**KIRKLEES METROPOLITAN COUNCIL
INVESTMENT & REGENERATION SERVICE**

DELEGATED DECISION TO DETERMINE PLANNING APPLICATIONS

| Reference No: | 2024/62/91460/W |
| Description: | Erection of detached building to create dwelling forming accommodation associated with The Old School, Dean Head, Church Lane, Scammonden, Huddersfield, HX4 0EA (Listed Building) |

South Elevation

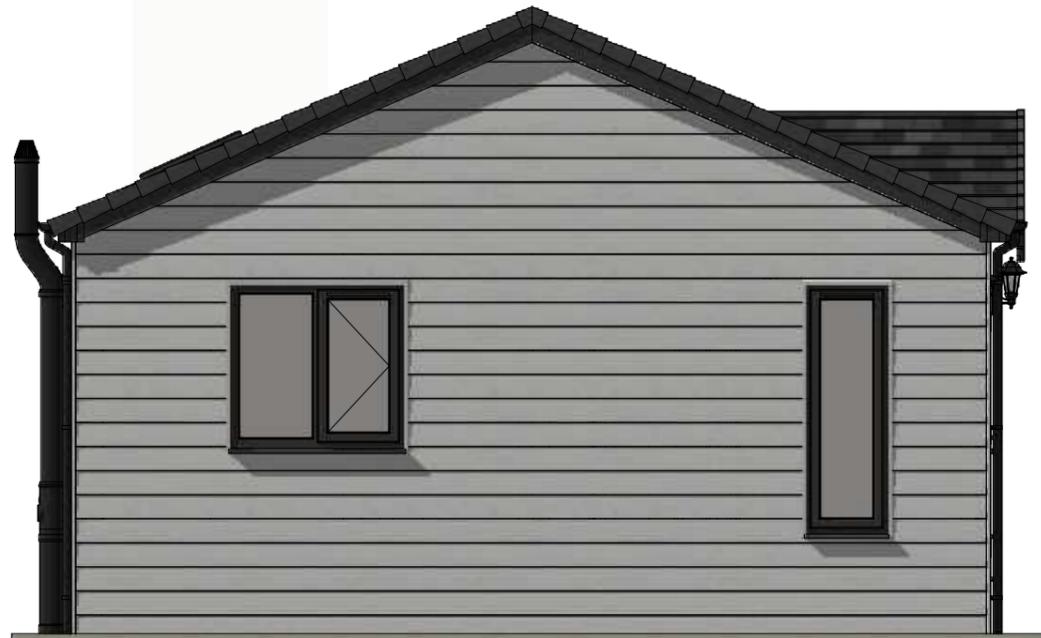
The scale, siting and materials proposed, the building would be very prominent and in terms of materials, at odds with the traditional stone construction of surrounding build form. The use of modern materials for the external walling is not sympathetic to the surrounding rural and historic character of the area and fails to respect the prevailing use of natural stone contrary to design principles set out in NPPF and Local plan policy.

3. The development of a building with the use of modern construction materials away from the existing build form introduces a building which does not relate well to the existing rural character of open countryside with stone built traditional buildings and therefore is contrary to Policy LP24 and Chapter 12 of the National Planning Policy Framework.
